Your Ref: OWQC22259
Our Ref: EP/25/19/HH
Please ask for:
Mr Z Denton

Construction of single storey rear extension; extension of first floor roof space; internal re-ordering; replacement of garage roof; replacement of pitched roof covering; new porch and side canopy; elevational alterations and associated works
12 Westfield Avenue East Preston

Thank you for your internet comments made on 18th April 2019 which has been recorded as **'an objection'** with the comments as follows:

West Elevation: Scale 1:100

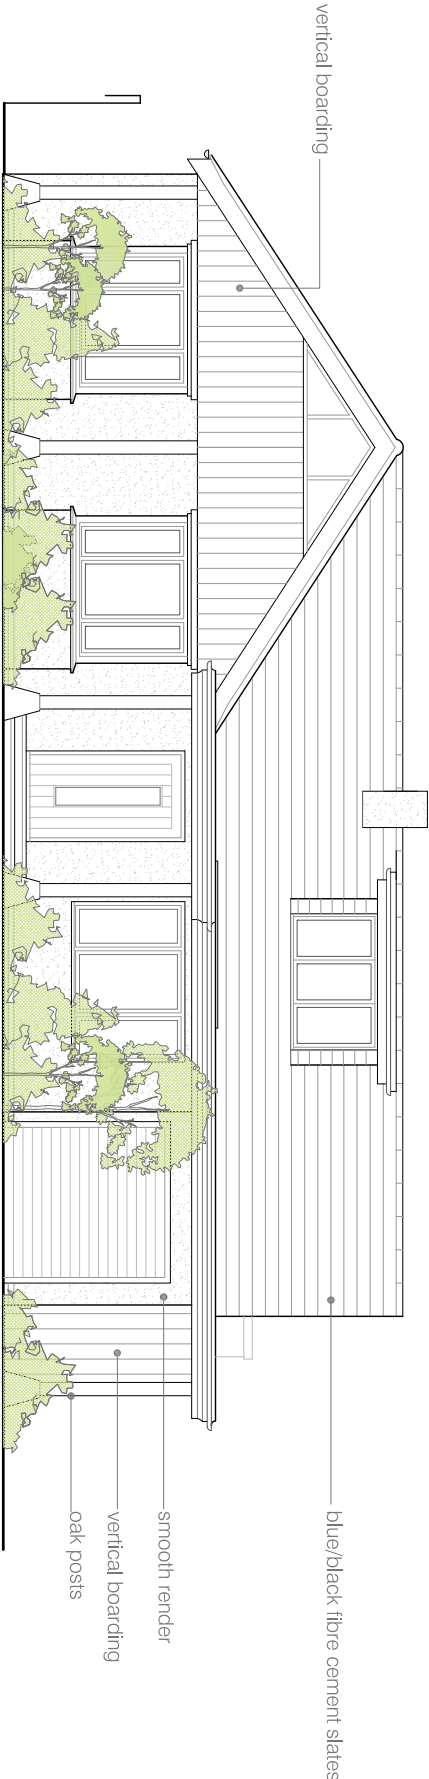
The committee agreed to object to this Application on the following grounds. The proposed dormer on the western elevation is very high on the roofline and would maybe look better lower down. It is understood the applicant is trying to improve the look of the existing dormer on the eastern elevation.

scale	date
1:100 @ A3	February 2019
job no	drawing no
18126	02.03

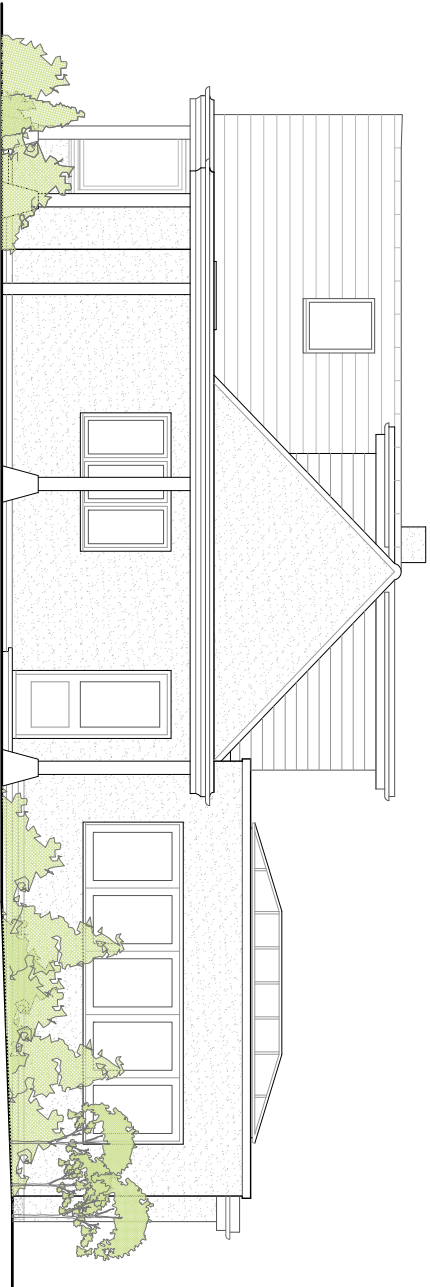
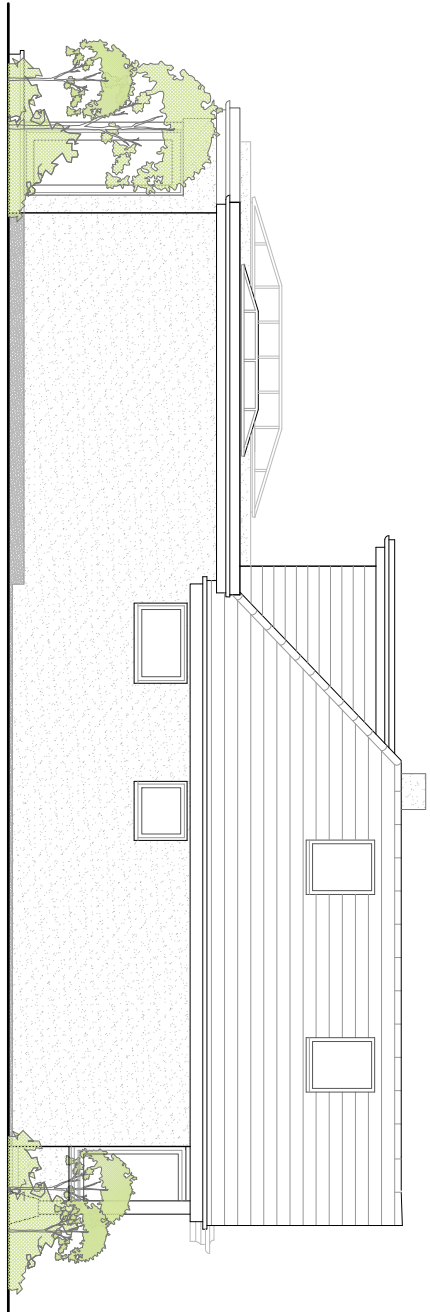
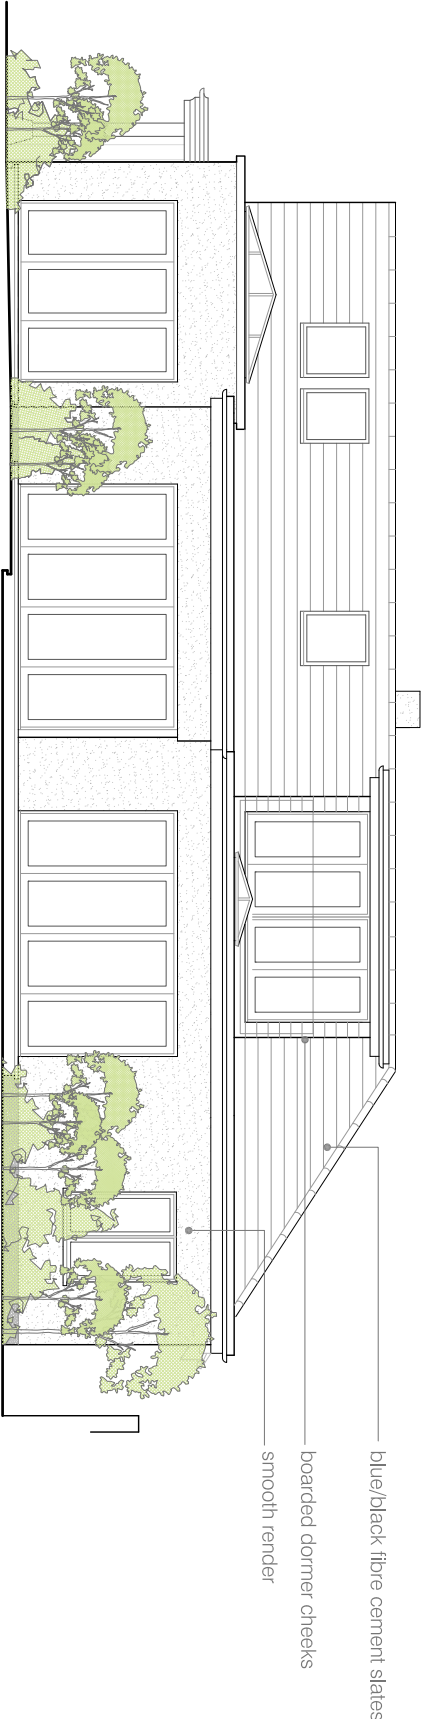
The choice of blue/black fibre cement slates, as per drawing 02.03 is not in keeping with other properties in Westfield Avenue. Materials should harmonise with the existing property and neighbouring properties, contrary to policy DDM1 of the Arun Local Plan, policy 1 of the East Preston Neighbourhood plan and the National Planning Policy Framework.
